From: Bruce Taunton
Sent: 25 November 2009 16:52
To: Planning.Responses
Subject: RE: Planning Consultation on: LU/304/09/

APPLICATION NO: LU/304/09/

Registered: 19-NOV-09
Site Address: New Cottage Toddington Lane Wick Littlehampton BN17 6JT

Description of Works: Demolition of existing dwelling and garage and redevelopment to provide 4no. 3 bedroom houses and 2no. 4 bedroom houses with new access off Toddington Lane.

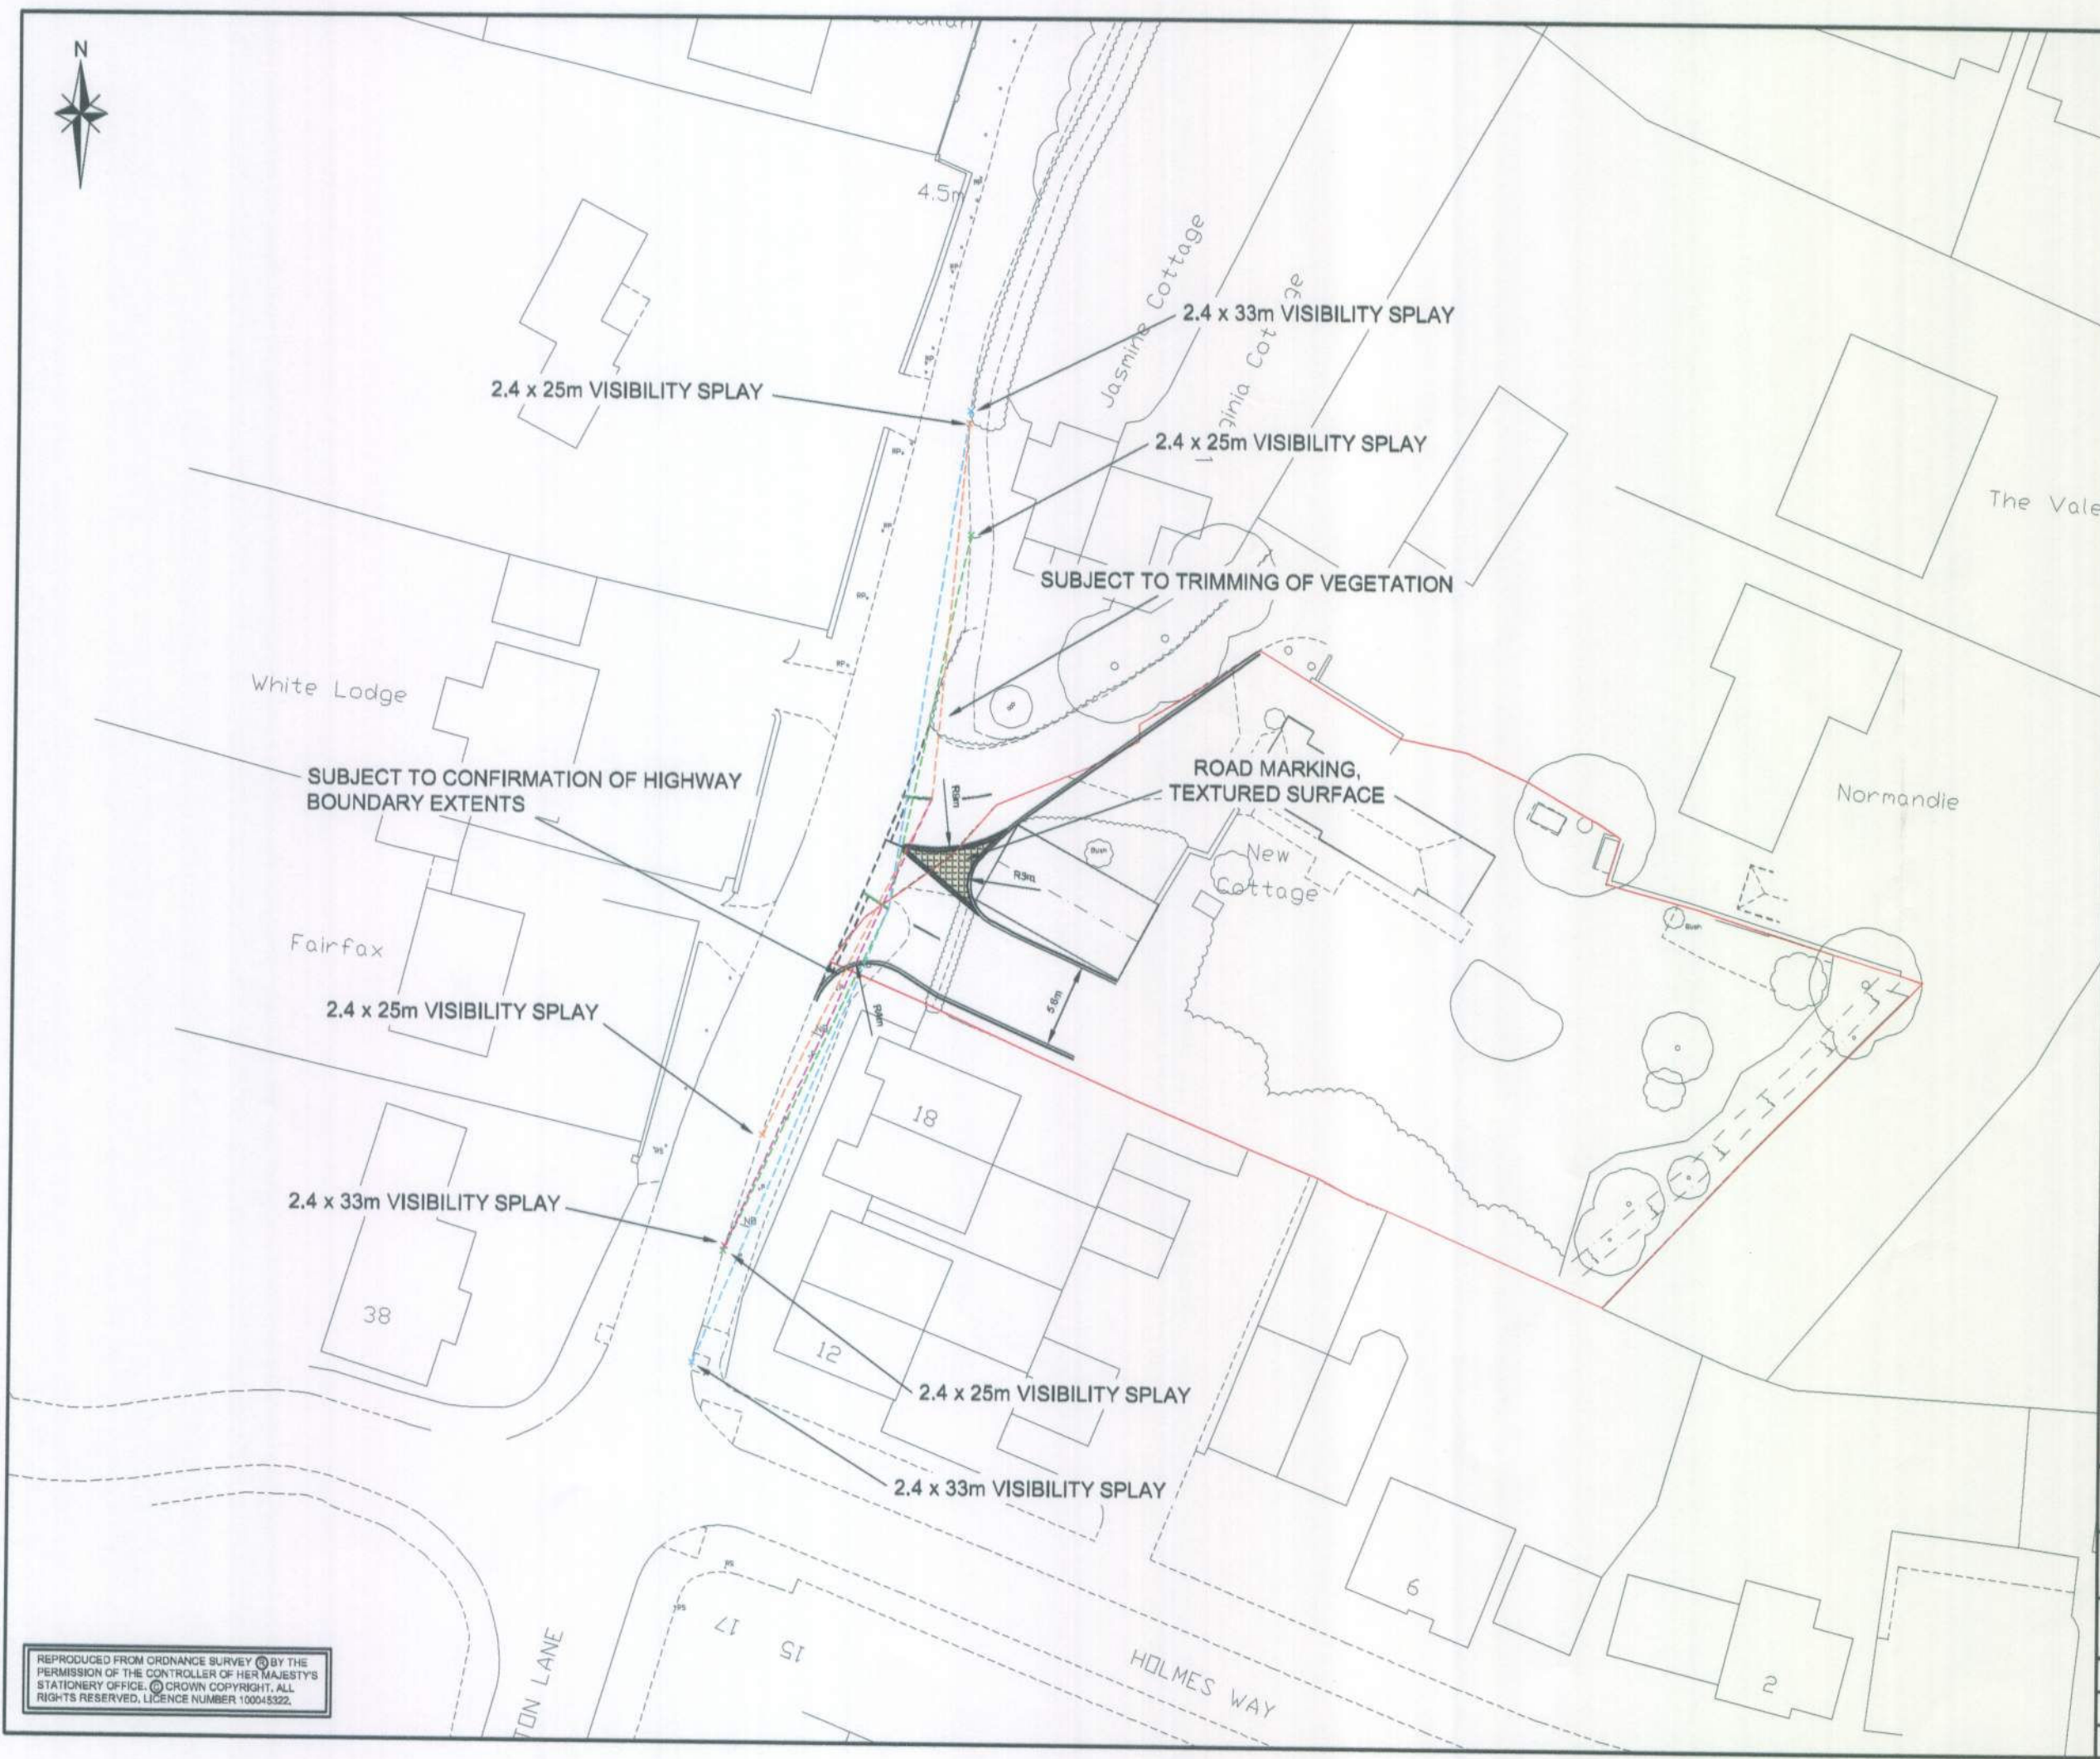
We have no comments on structural issues, however we assume that details of the road layout and junction will be forwarded to WSCC Highways for their approval. In addition we have observed that there does not appear to be any information about boundary treatments between either new and existing or between new properties.
